Your ref: 2024/91729
152 Northgate, Almondbury, Huddersfield, HD5 8US
Erection of single storey rear extension and terraced
steps (within a Conservation Area)

I should be very grateful if you would accept the following as my objection to the proposed single storey extension referred to:-

DWG NO. 2420 - 01

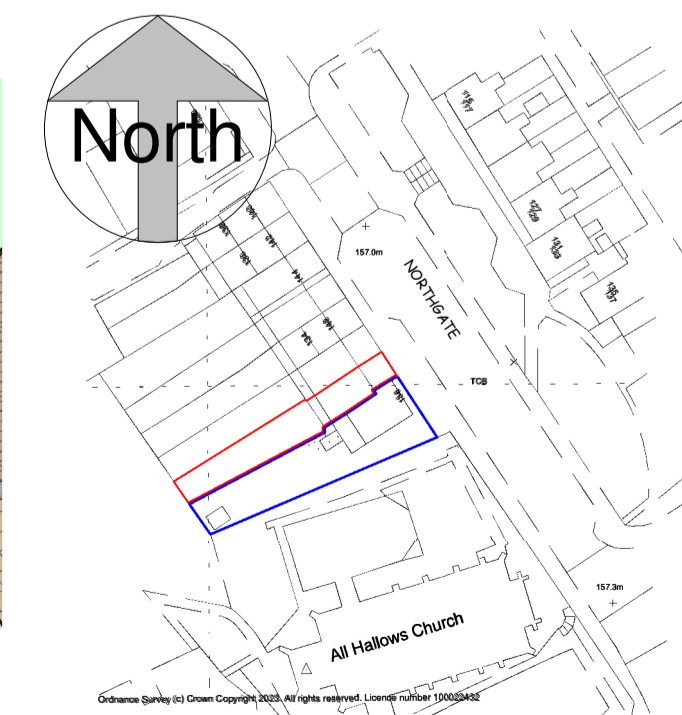
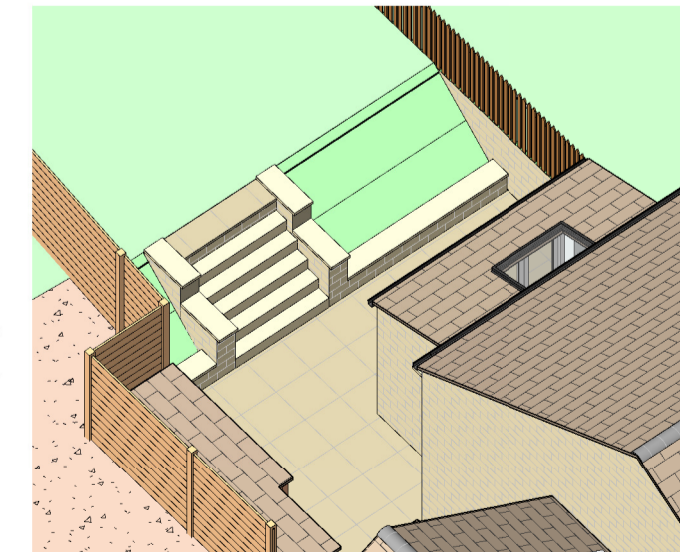
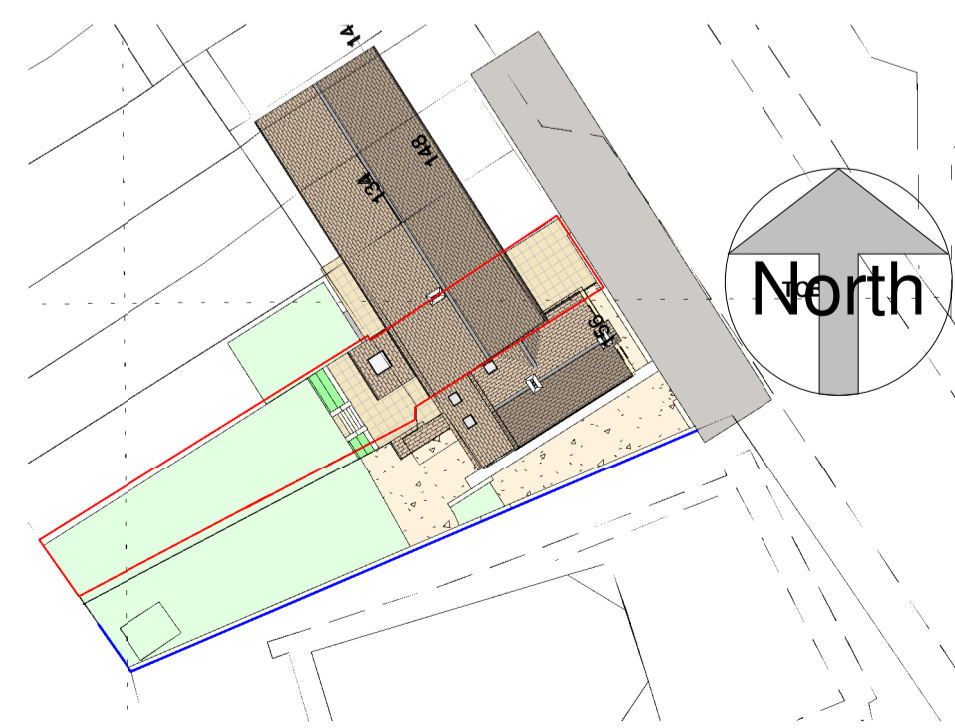
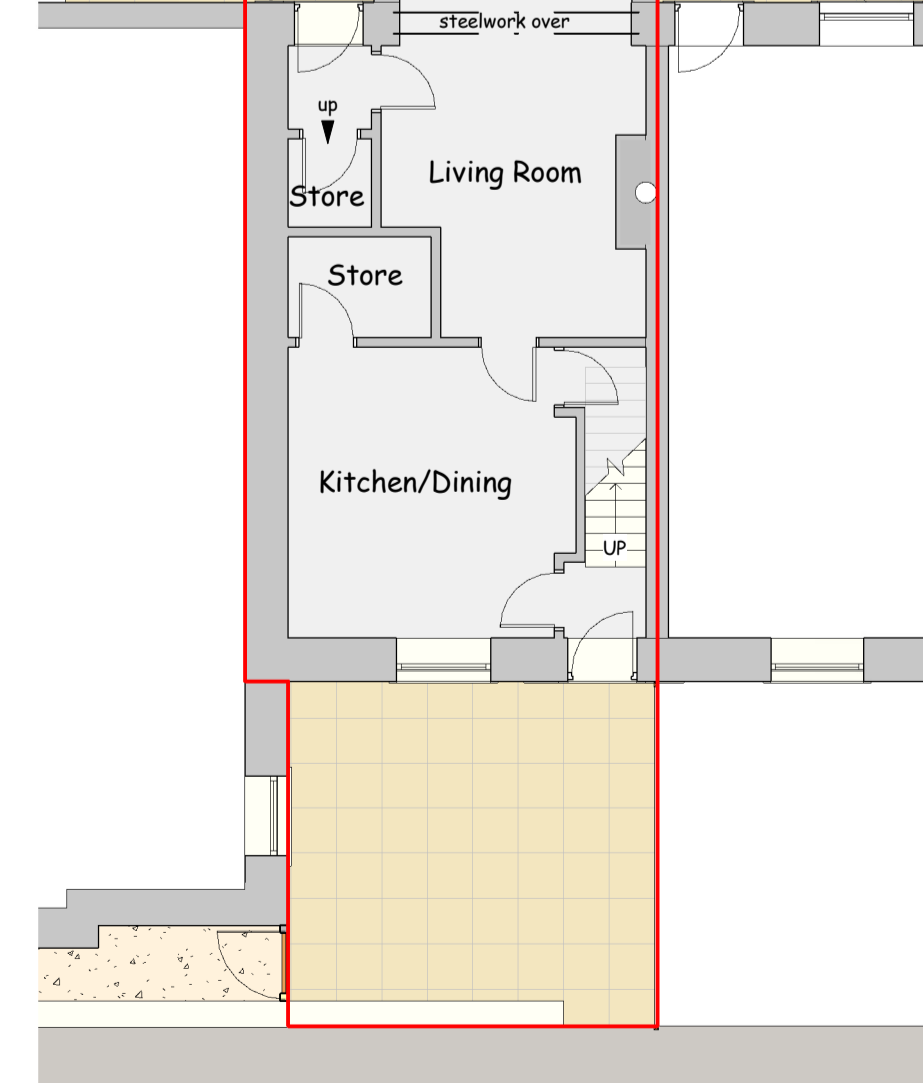
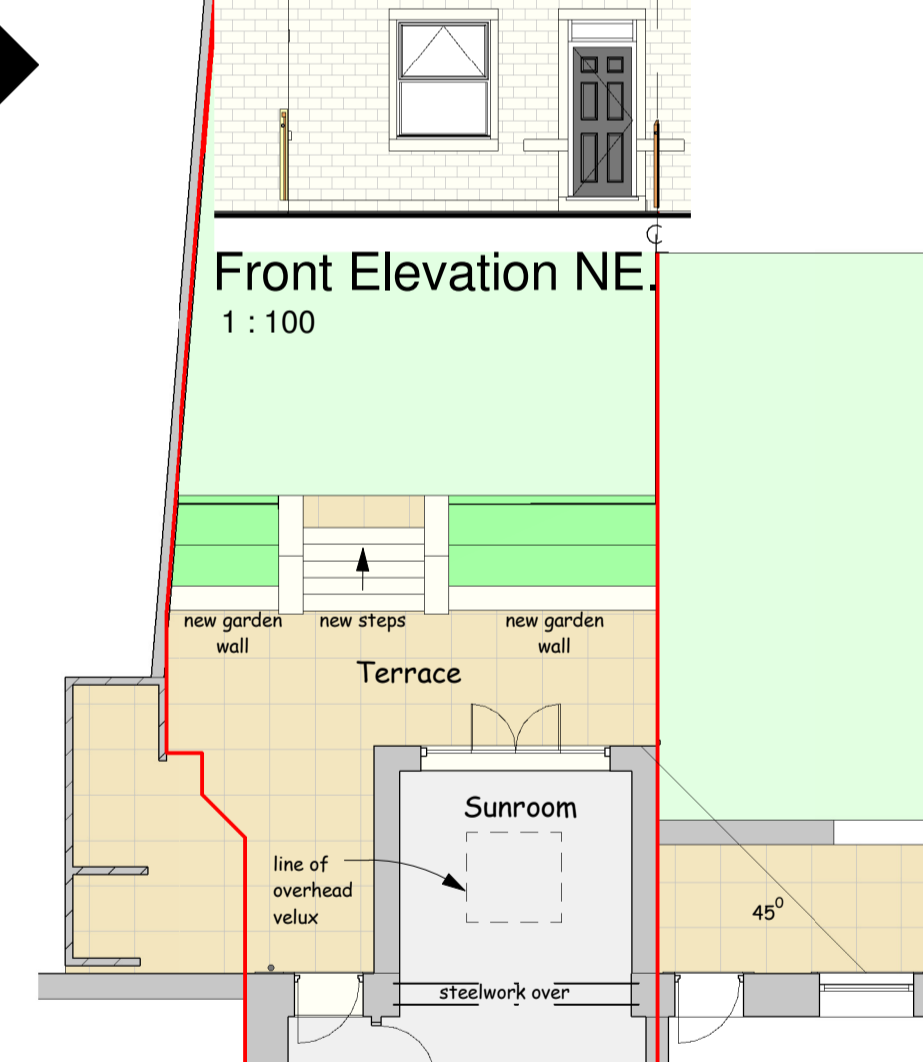
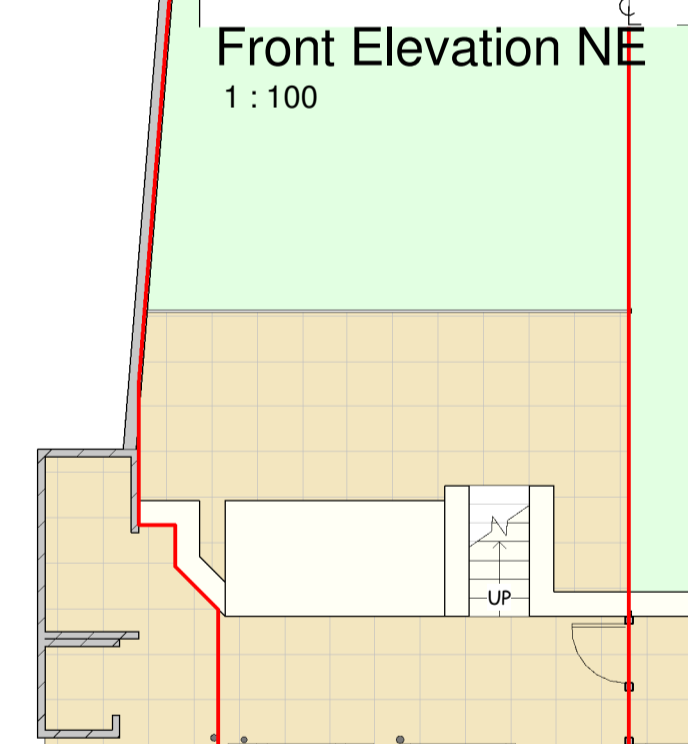
Although the construction is described in the application as a single storey, it in fact features a steeply sloping roof so that, at its highest point, it is virtually two storeys. This greatly increases its impact on the amenity of my own house in the following ways:-

- A. Light to the rear of my house is blocked or reduced. The Council will be aware that in 1987, when it was the owner of my house, it granted to the then tenant of it and the tenants successors in title (which is now me) "all rights of light as at present used or enjoyed by the Council in respect of the Property". This extension, if allowed to be constructed, would constitute a breach of those rights. The same would I think apply even if the extension was truly one storey.
- B. One of the attractive and enjoyable features of my house is that I have a very pleasant view, both from the rear window at ground floor level and also from the garden, of All Hallows Church. I attach a photograph in order to illustrate. This view has given me great pleasure over the years and will now be denied to me if this extension is permitted. I believe I have a legal right to this view.

- C. The proposed extension is not in any event in character with the prevailing architecture of the terrace. Furthermore, it will significantly diminish the character of my own rear garden. This is important because the terrace is situated at the side of a busy road at the front, so that the rear gardens are of greater importance to each householder.
- D. On a purely material level, the value of my house is going to be reduced by the presence of the extension (if constructed) whilst, at the same time, the value of the applicants house will be increased. Please note that the applicants are investors, that is to say they do not use 152 Northgate for their own occupation.
